Our Case Number: ABP-314942-22

Re: BusConnects Lucan to City Centre Core Bus Corridor Scheme
Lucan to Dublin City Centre

Lucan to City Centre Bus Corridor

KENNELSFORT ROAD FOOTBRIDGE TO BE RETAINED

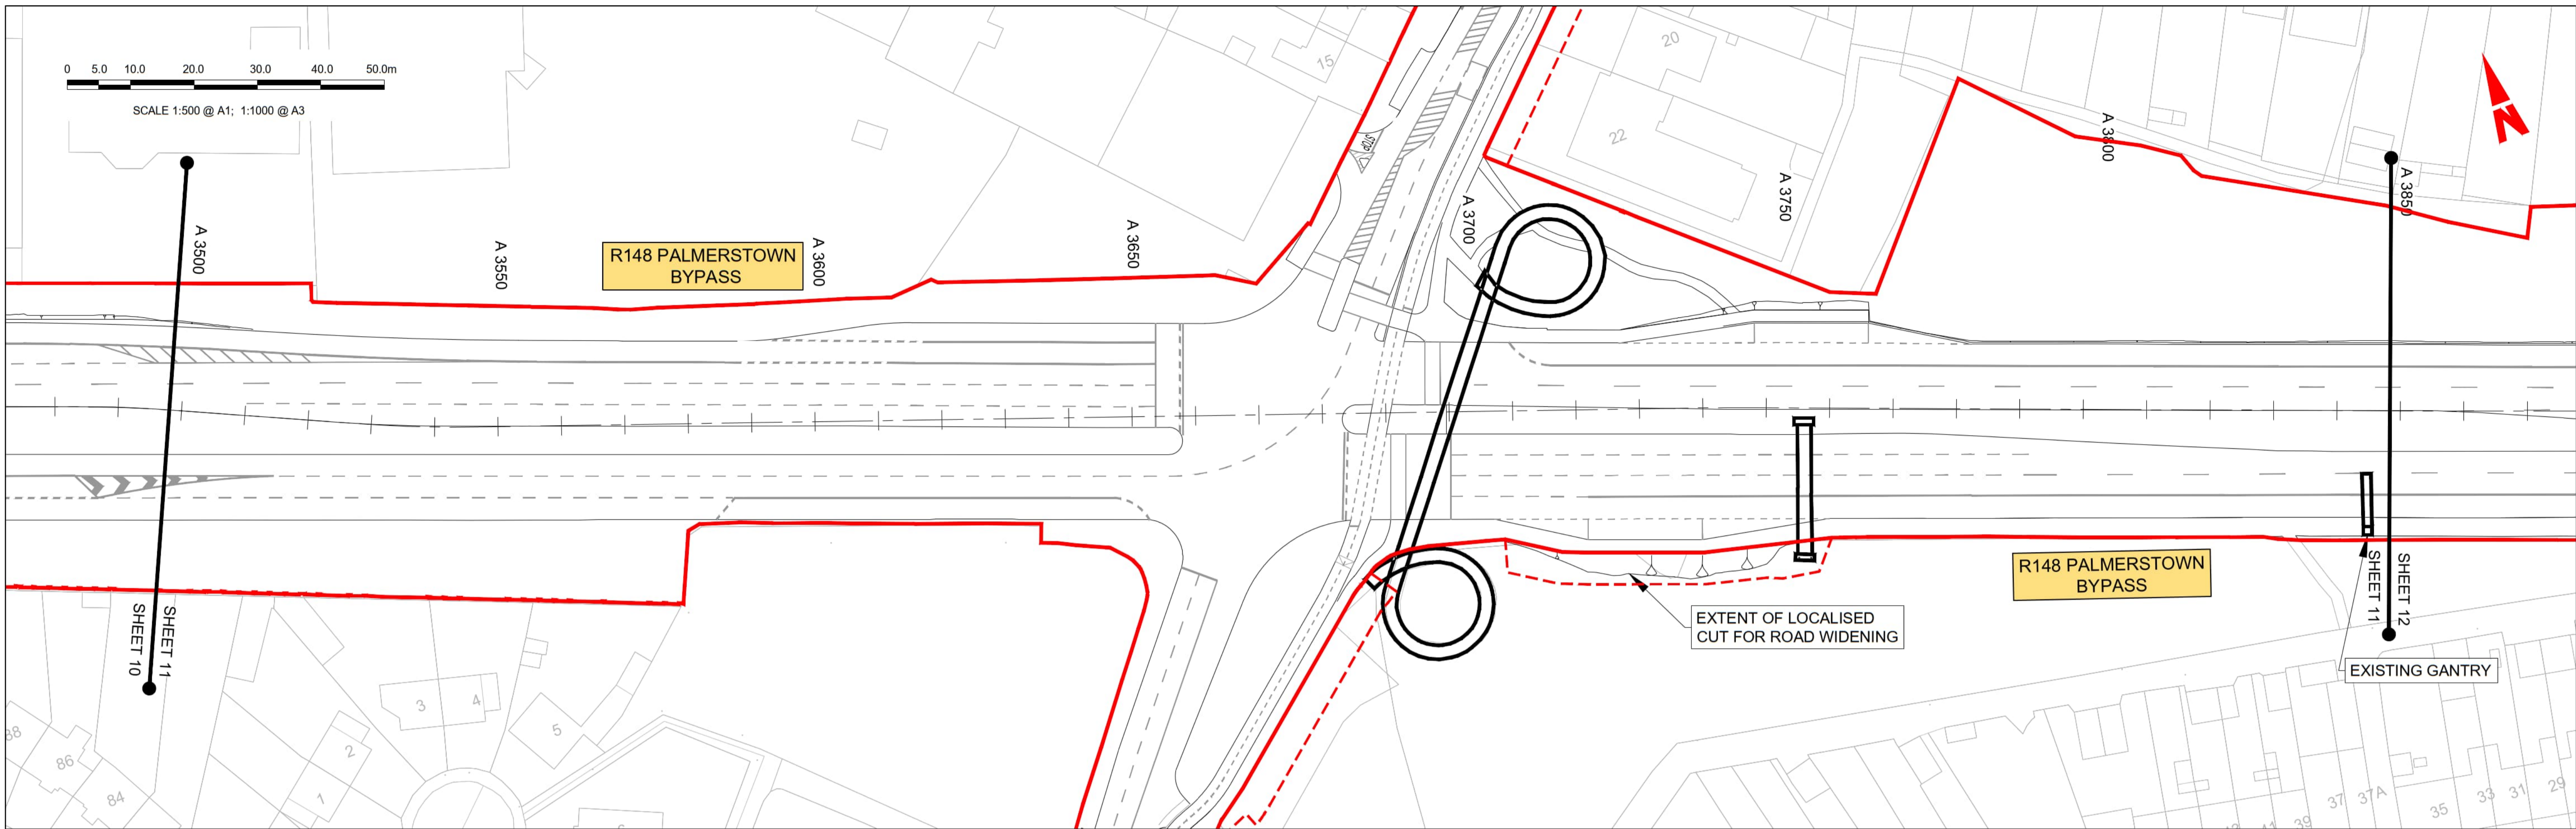
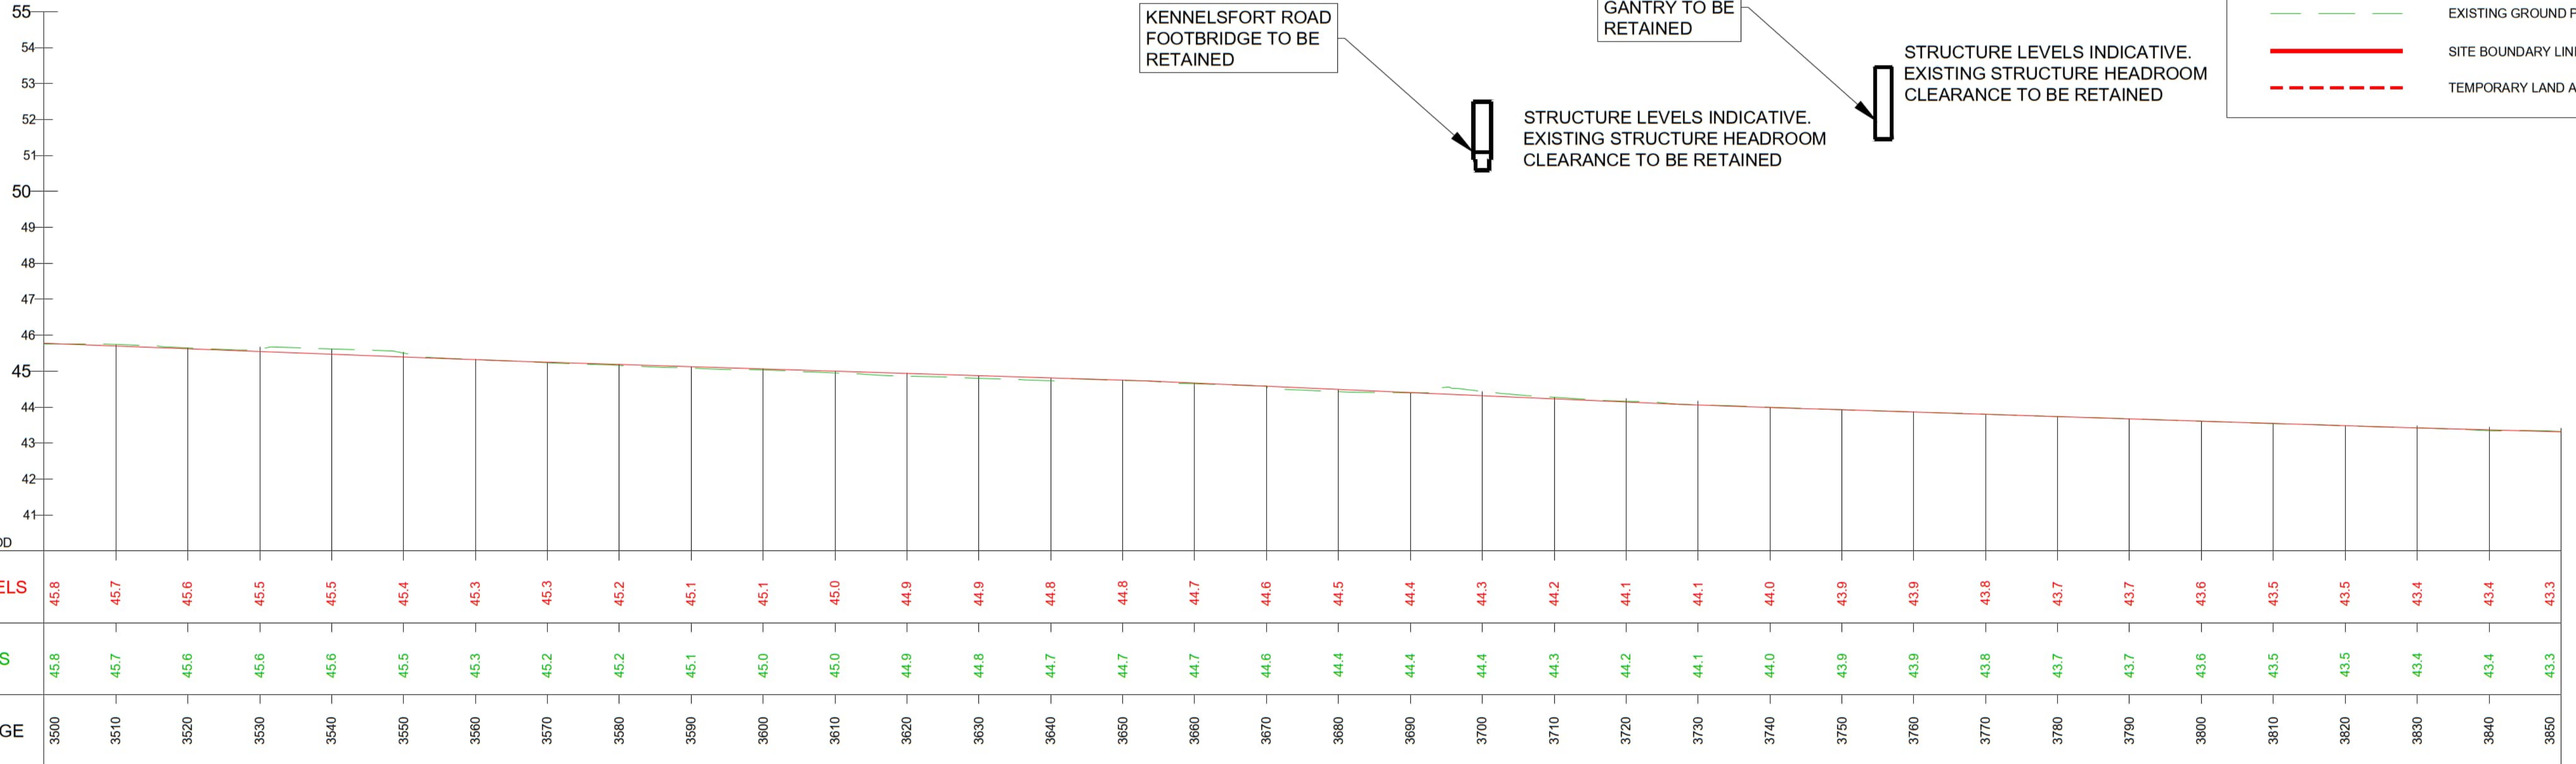
- Pedestrian Safety: Current footbridge is safer than moving it to a road with fast moving traffic
- Cycle safety: Cycle lane on Upper Kennelsfort road is on both sides of the road following the flow of traffic, lower Kennelsfort road should have a cycle lane on each side following the flow of traffic
